2 October 2015

Our Ref: SE/CL/2015/38607/S

Application No:	14/02004/HYBRID (CDC) & 14/02063/OUT (WODC)
Site Address:	Land South of Perdiswell Farm, Shipton Road, Shipton On Cherwell, OX20 1QR
Proposal:	OUTLINE: Up to 1,500 dwellings, including affordable housing and up to a 150 unit care village (C2) with associated publicly accessible ancillary facilities; site for a new primary school; up to 930sqm of retail space; up to 7,500sqm locally led employment (B1/B2/B8) including link and ride; site for a Football Association step 5 football facility with publicly accessible ancillary facilities; public open space; associated infrastructure, engineering and ancillary works, (all matters reserved except for means of access to the development); and FULL: development of Phase 1 at the south western corner of the site for the erection of 29 residential dwellings (29 of the 1,500 described above) with associated open space, parking and landscaping; with vehicular access provided from Upper Campsfield Road (A4095), Shipton Road and Oxford Road (A44).

Job	273	Dwg No.	P111	Rev.	-
-----	-----	---------	------	------	---

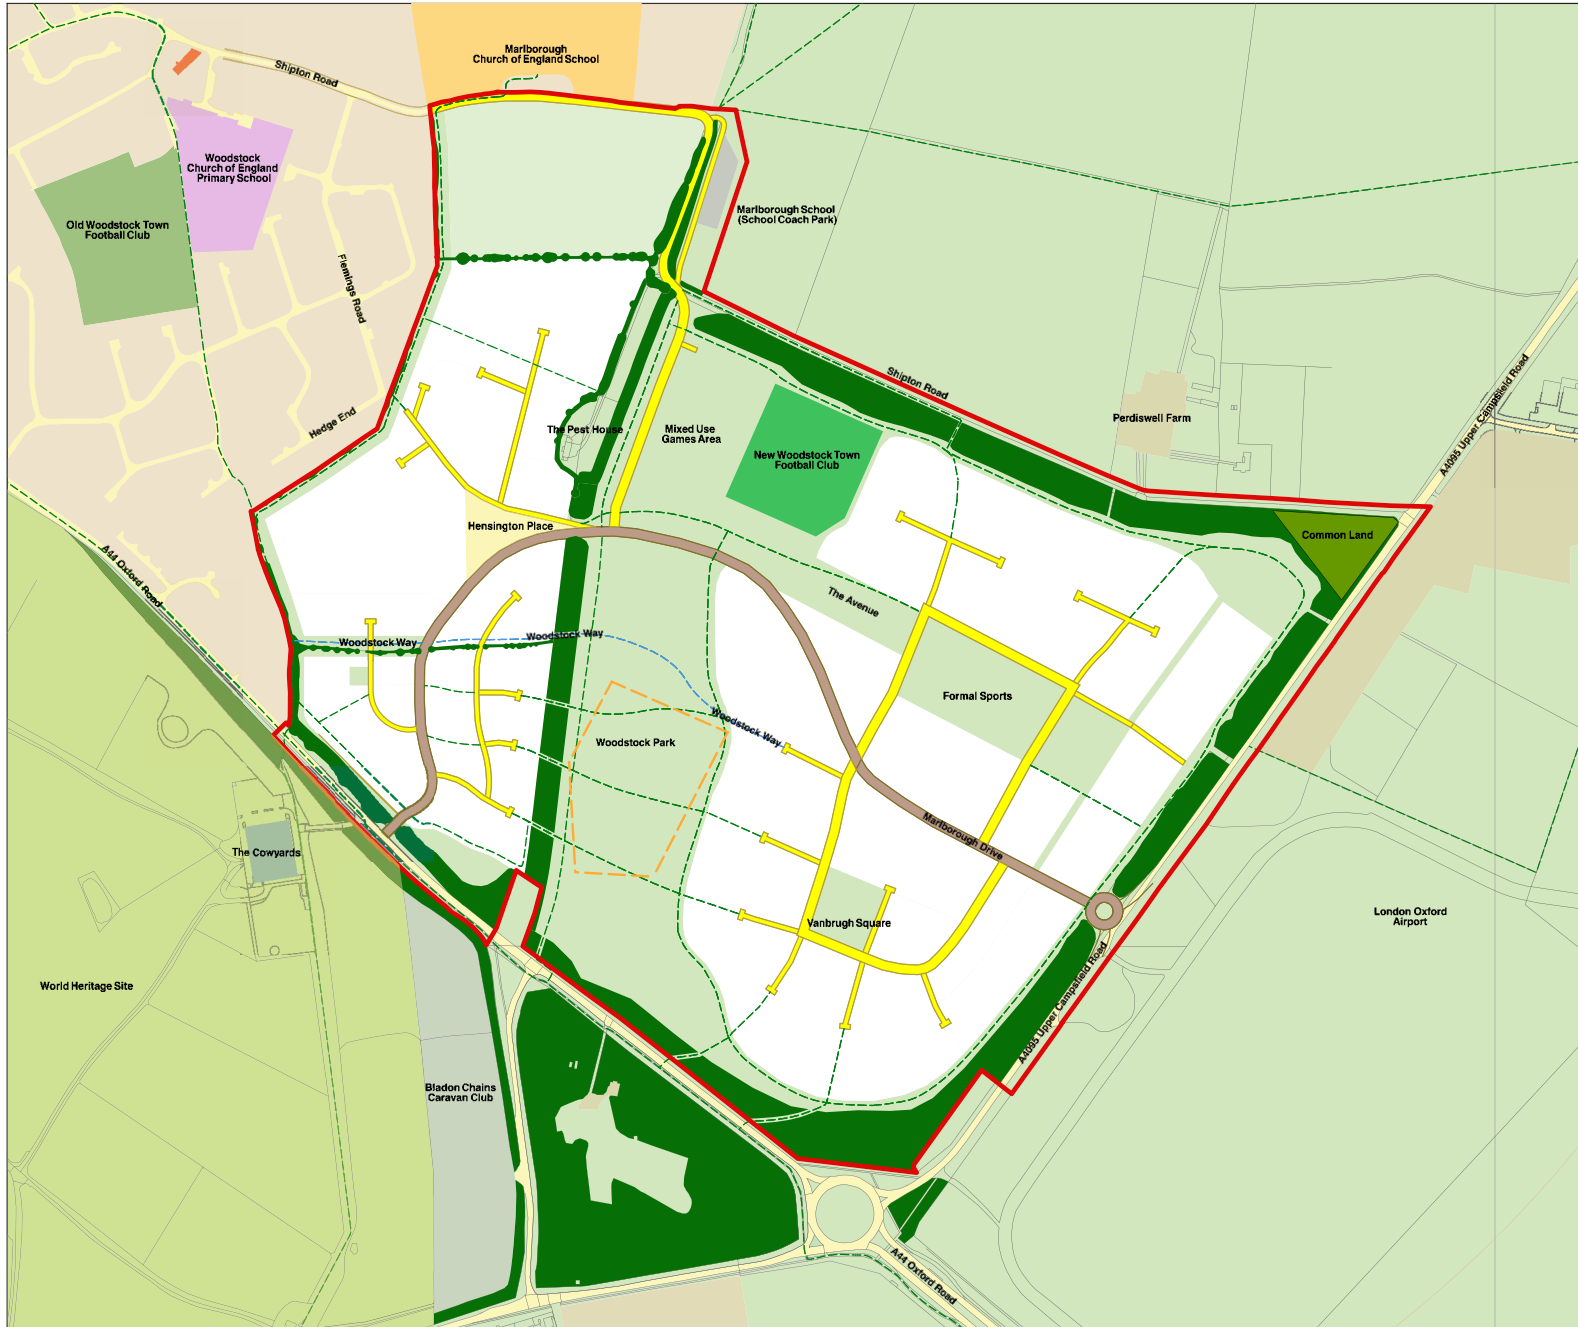
While it is noted that the agent’s letter dated 22 May 2015 described the drawings numbered P201 and P202 as “Illustrative Masterplan”, neither of the two drawings appear to carry that title or a note that they are “for illustrative purposes only”. Similarly, the Movement & Access (drawing numbered P111), Green Infrastructure (drawing numbered P112), Density Plan (drawing numbered P113) and Land Use Plan (drawing numbered P114) do not contain a note that they are “for illustrative purposes only”. They are, however, identified as parameter plans in the Design Response Document May 2015. Therefore, they would set the framework within which details could be expected to come forward at the reserved matters stage.

Unless the correct framework is established, it is unlikely that the proposed sports facilities would function satisfactorily and be sustainable in the longer-term. A sports ground on the eastern side of the site, that is bisected by a “Secondary road corridor”

and detached from the Football Club site, has the potential to give rise to a range of management and maintenance problems. Ideally, the sporting facilities should be located on a single site to give critical mass, increase footfall and achieve economies of scale.
